Please ask for: Mrs D Johnson
Email: daun.johnson@arun.gov.uk
Telephone: 01903 737762
Our Ref: LU/72/25/OUT
Your Ref:
Date: 23rd April 2025

Application for Outline Planning Permission

Development: Hybrid Planning Application comprising of the following:
1)-Outline application with all matters reserved (except access) for Phase 2 (West of Site) comprising development of approximately 8,800sqm GIA Light Industrial/Storage and Distribution (Use Class E(g)(iii) / B8), and
2)-Full Application for Phase 1 (East of the Site) for a food store (Use Class E(a)), 2 No Drive-Thru food/beverage units (Sui Generis) with revised vehicular access, associated parking and landscaping. This application may affect the setting of a listed building and is in CIL Zone 2 (Zero Rated) as other development.

Location: Land To The West Of New Courtwick Lane Wick BN17 7RZ

03 East Elevation
1:100

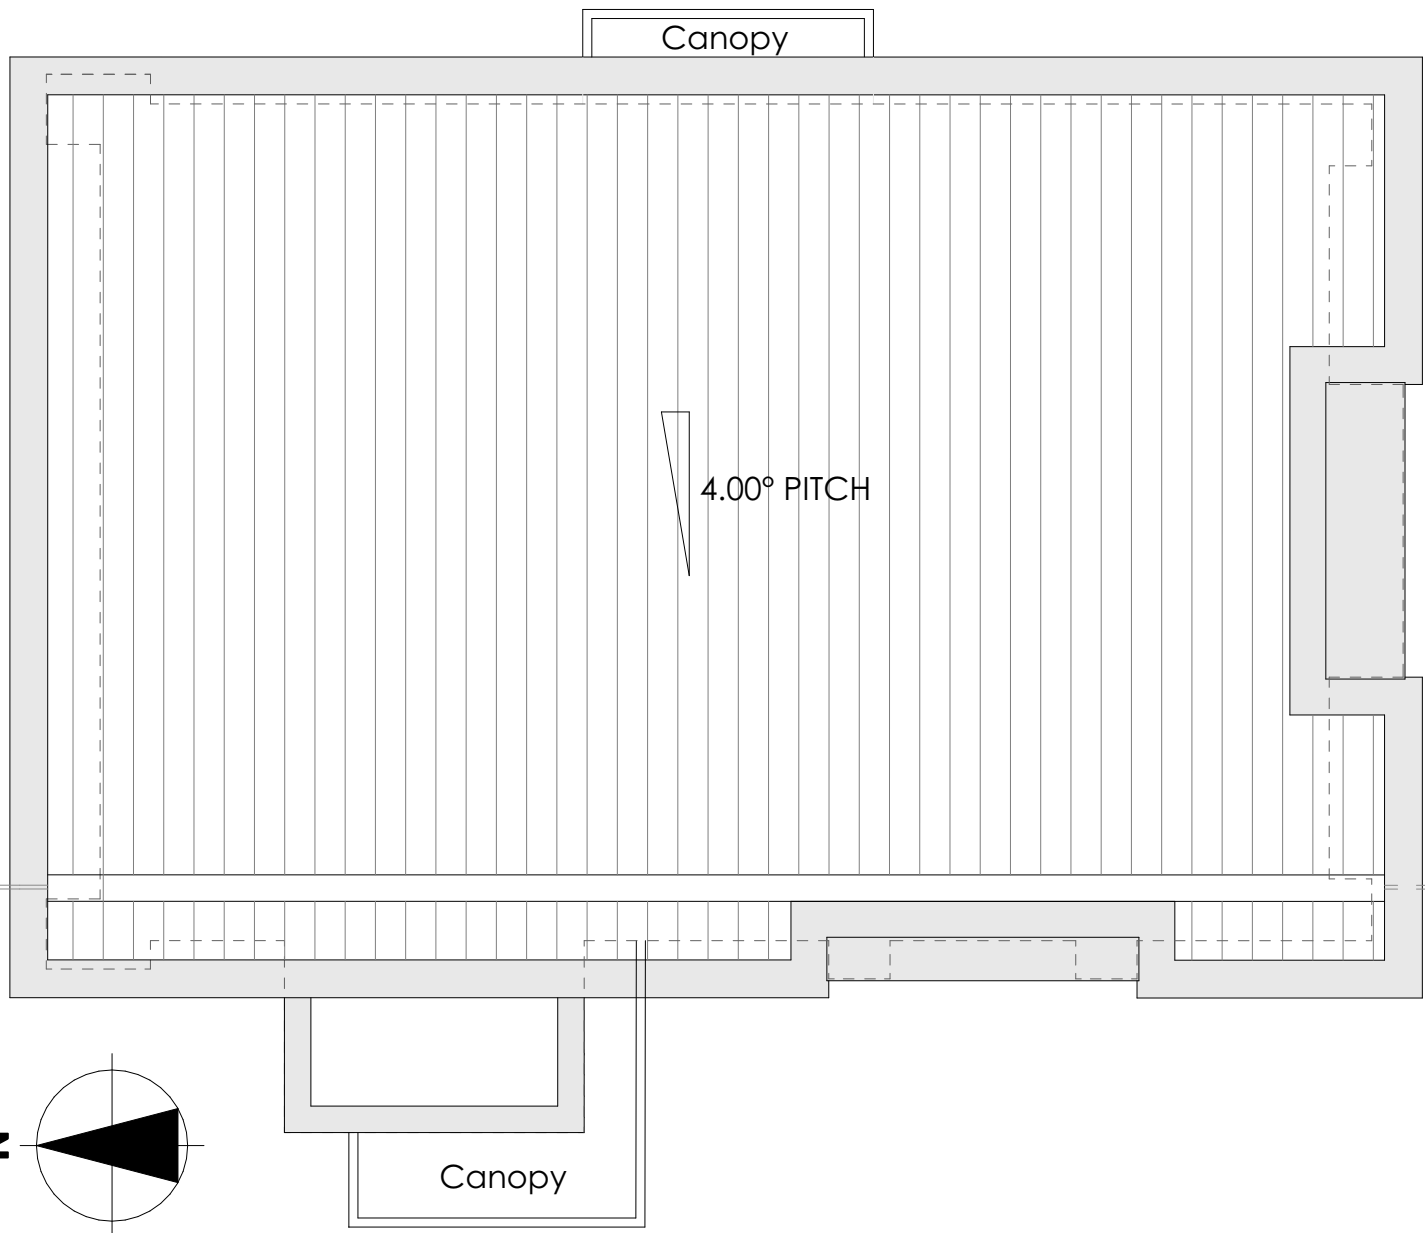
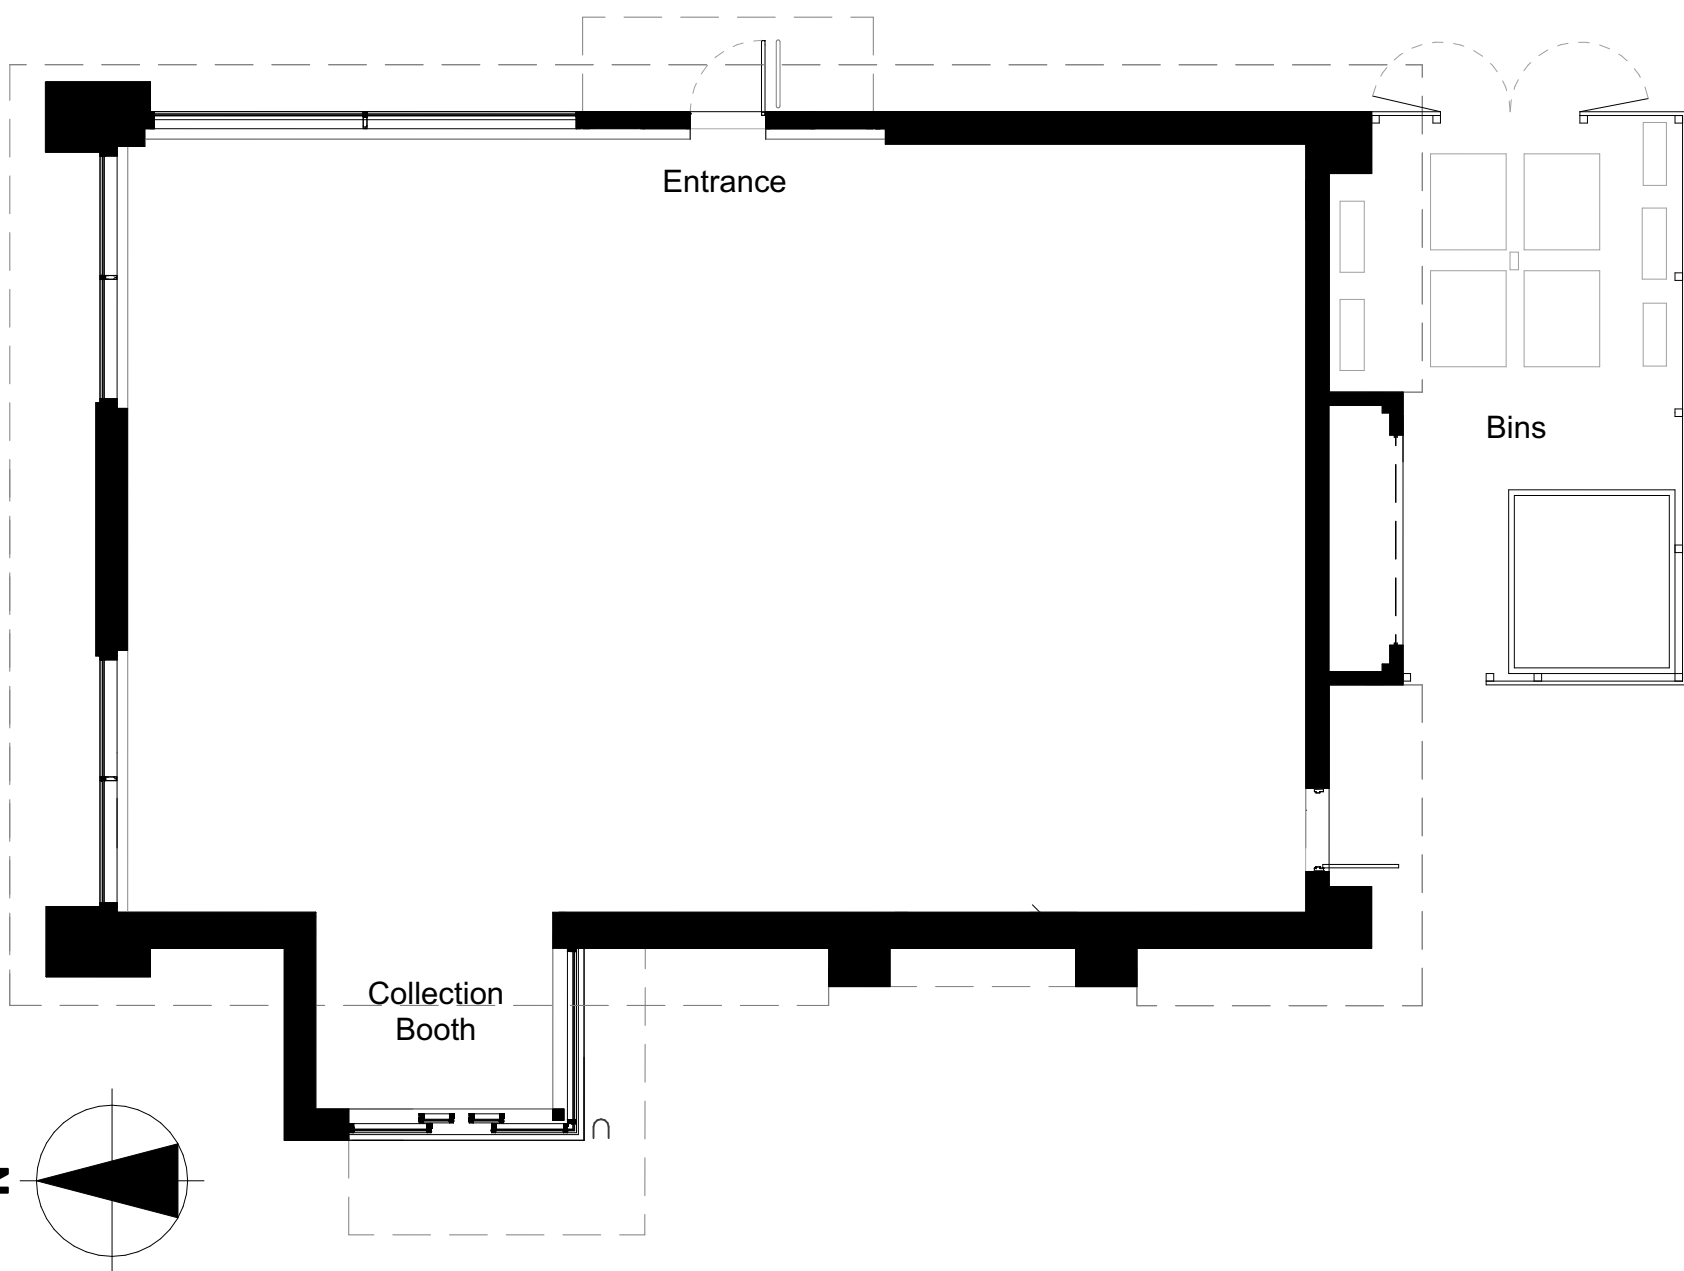
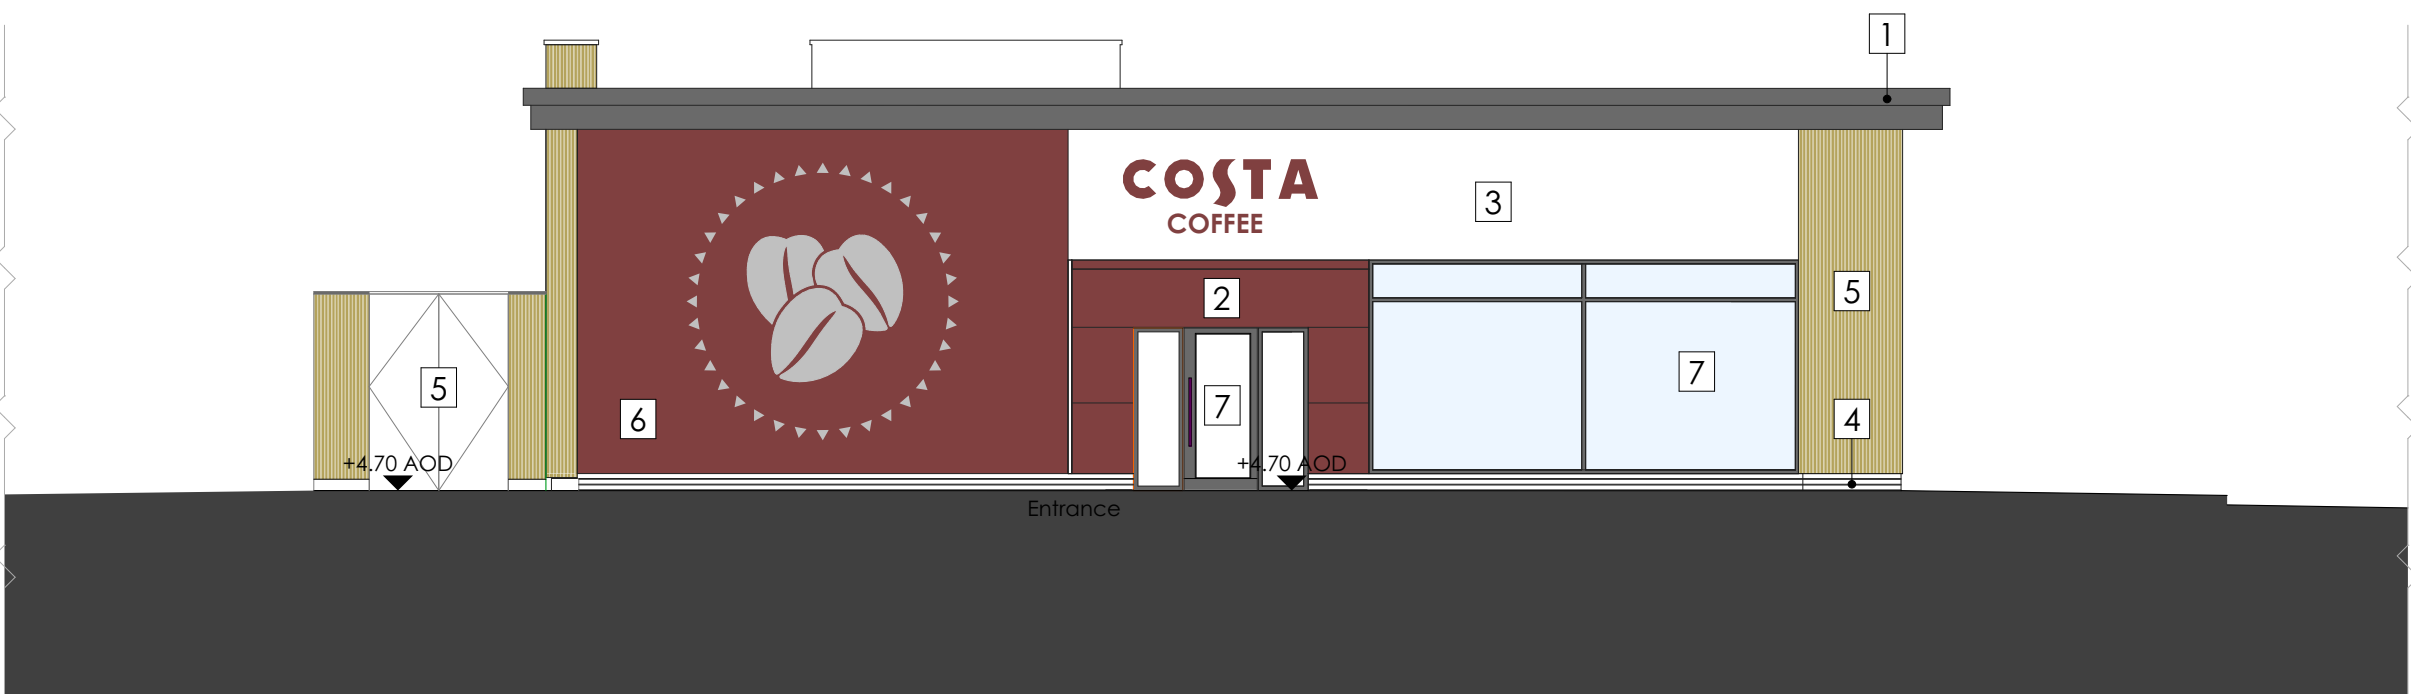
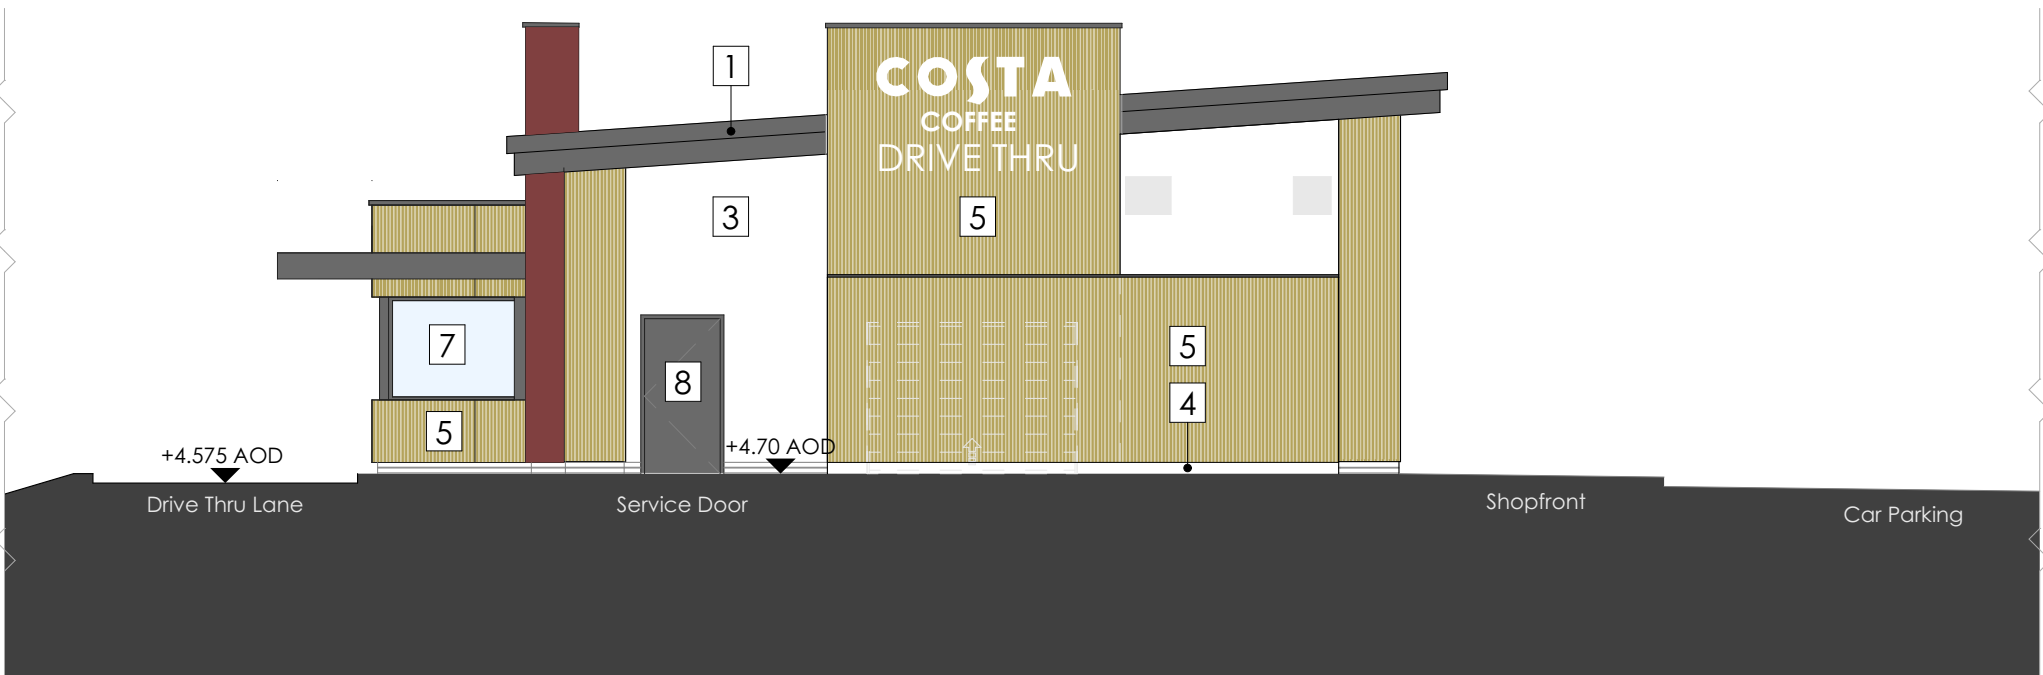
The food store east elevation and ground floor plan do not accord. Please amend accordingly.
